December 20, 2023

Attn.: Mr. Brad Walters, Inspection Supervisor
RE: Solace Apartments Filing No. 1 – Pond Certifications

This letter is intended to provide documentation with County Inspection Staff that the Pond facilities in Solace Apartments Filing No. 1 have been constructed within reasonable conformance to the design. The District owned pond facilities for Solace Apartments Filing No. 1 are described by the following:

SOLACE APARTMENTS FILING NO. 1	POND B PLAN & CROSS SECTIONS
SHEET 21 OF 32	JOB NO. 25174.00

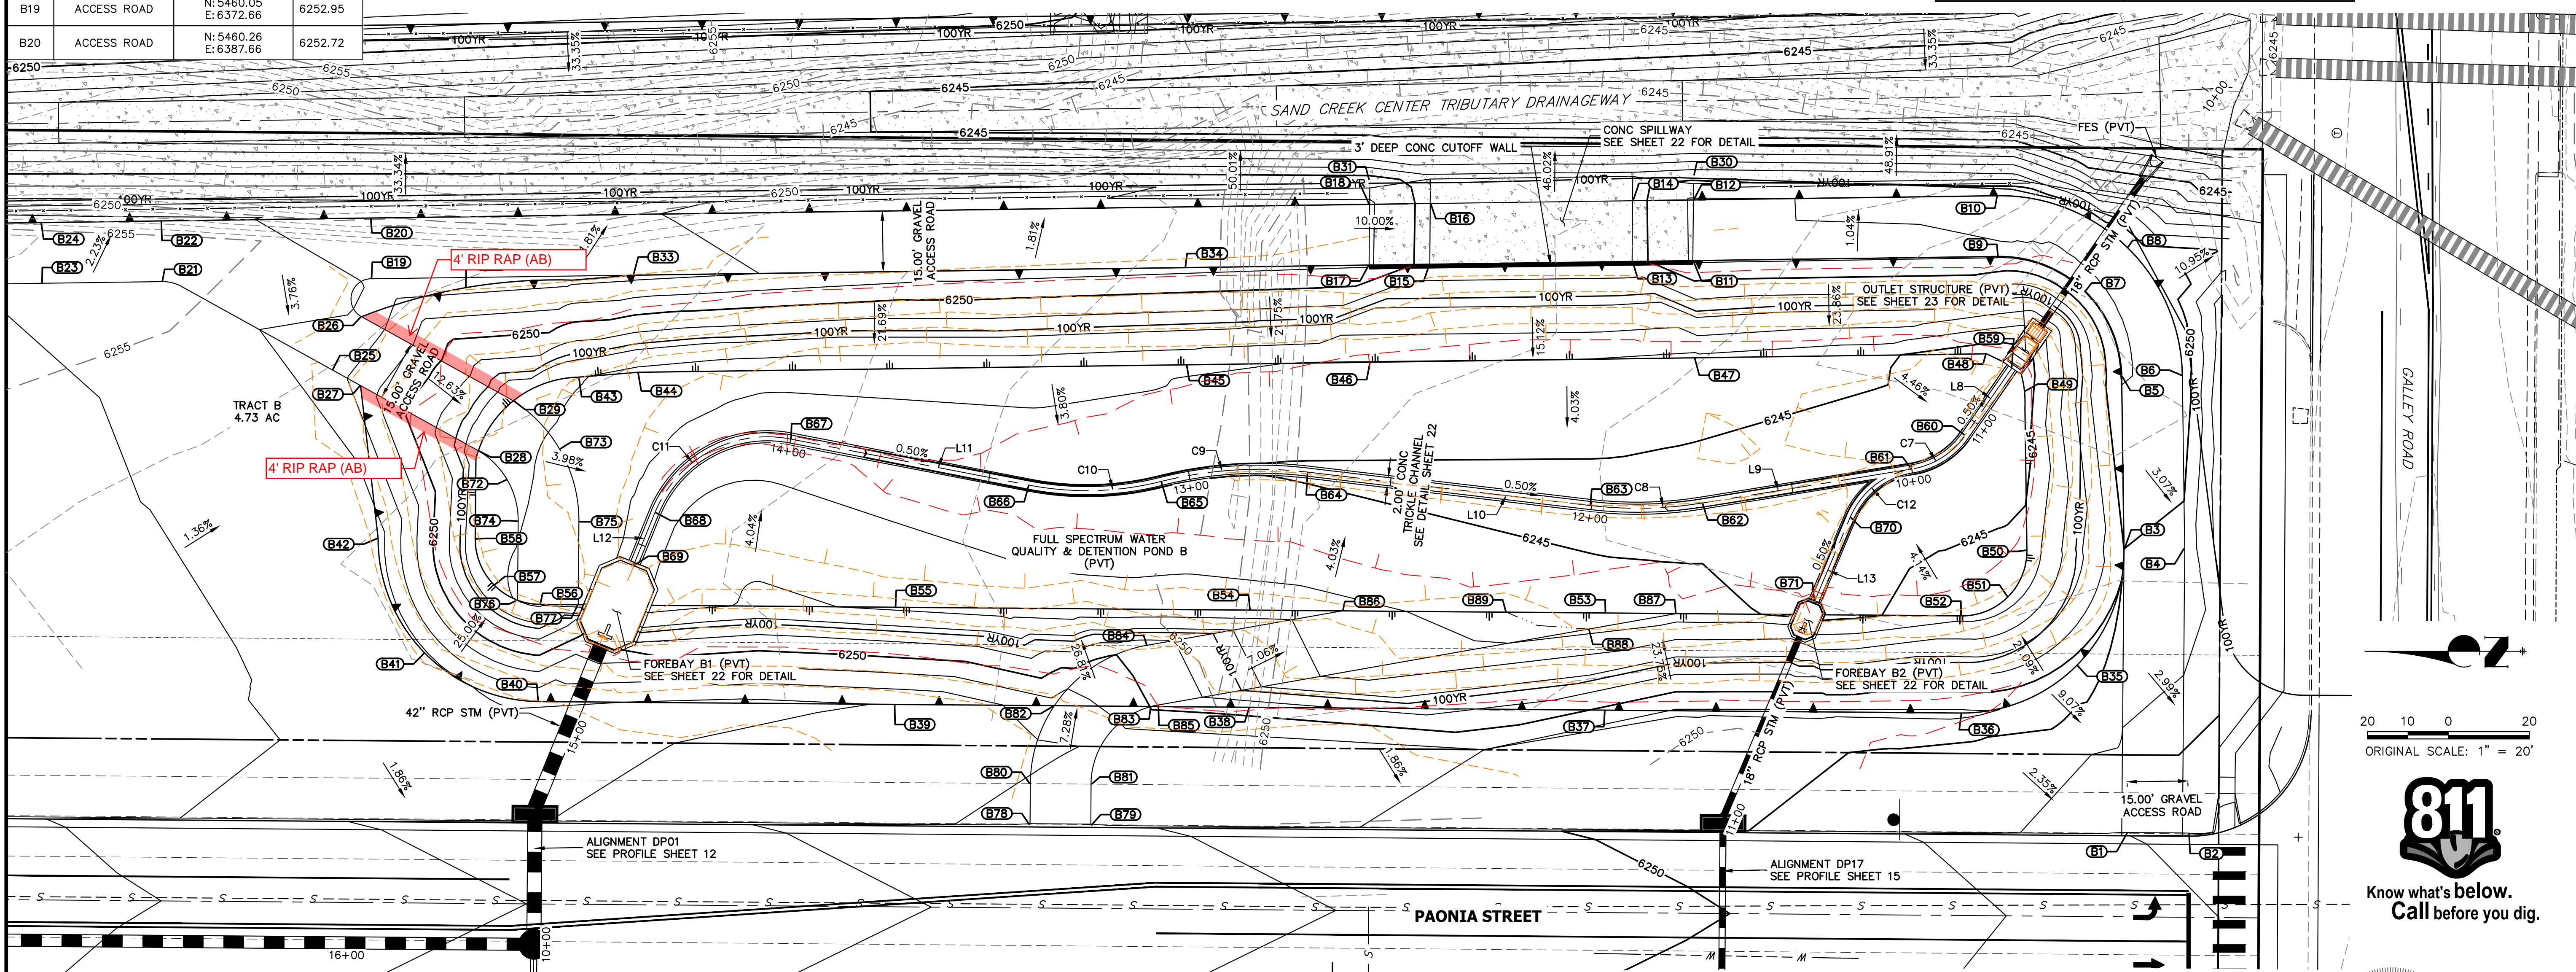
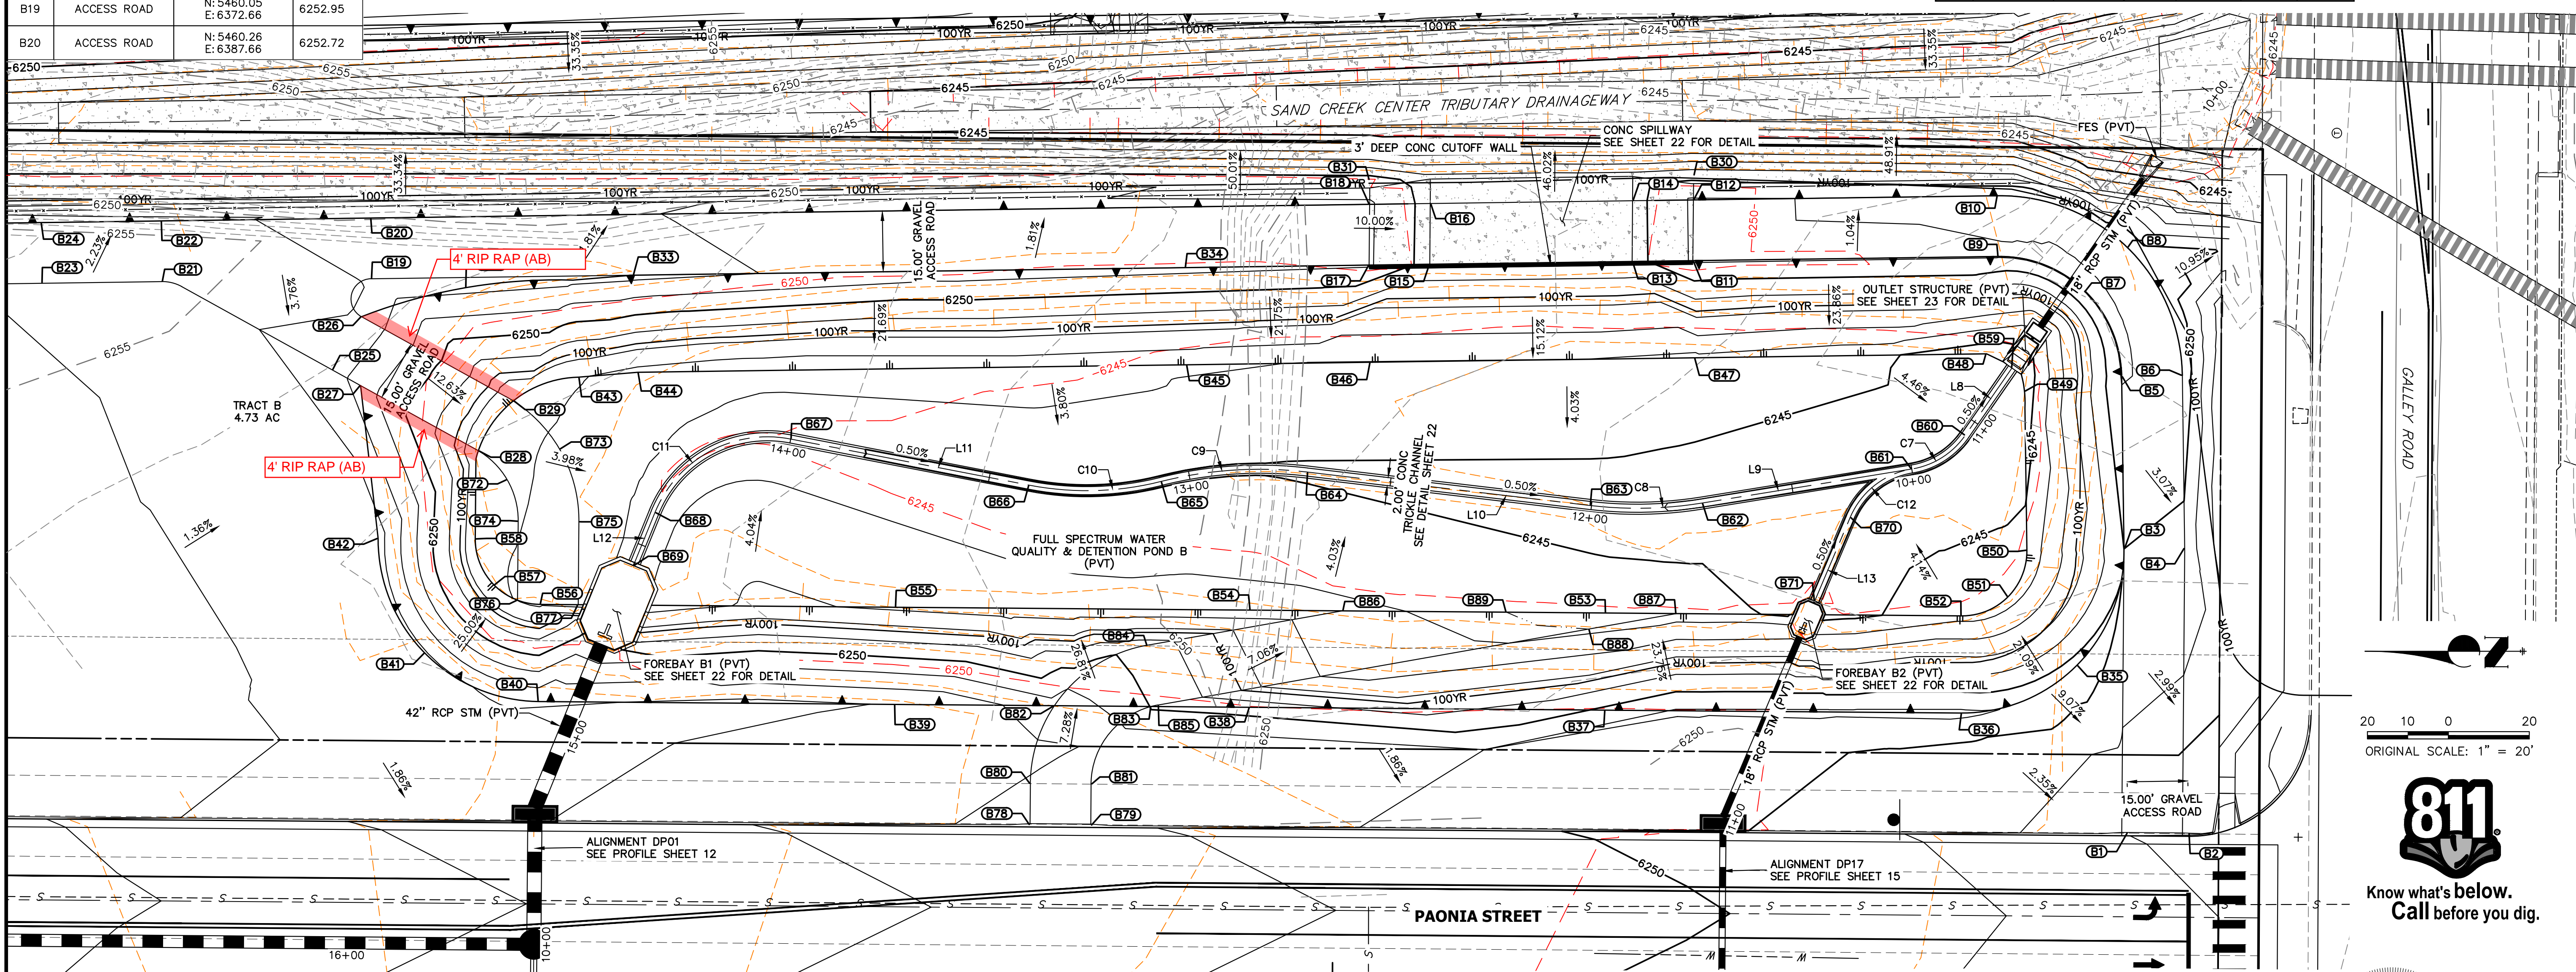
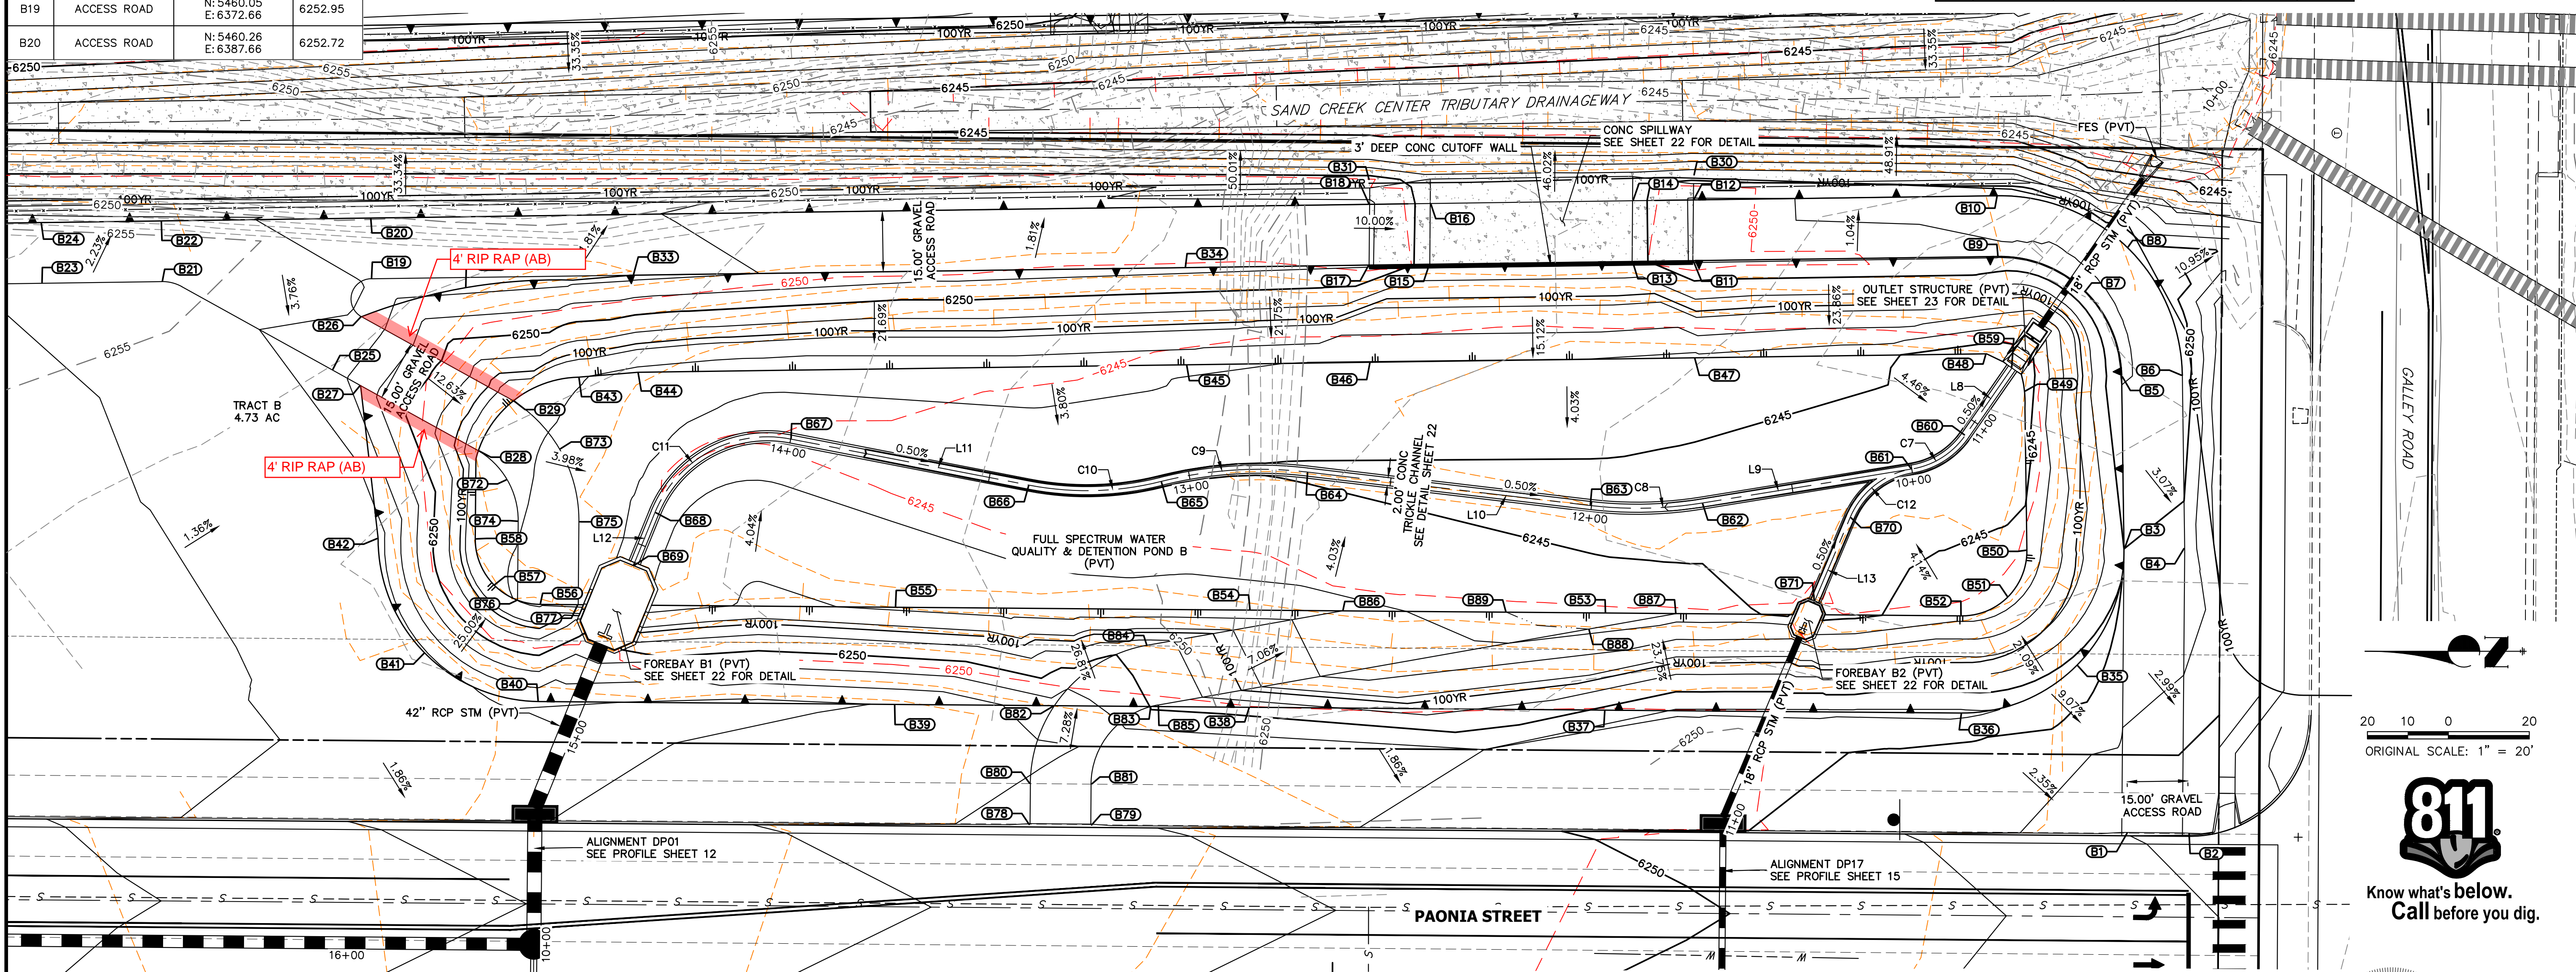
The drain time exceeds the allowable limits for the 2-year and 5-year. The pond must be within allowable ranges for drain time.
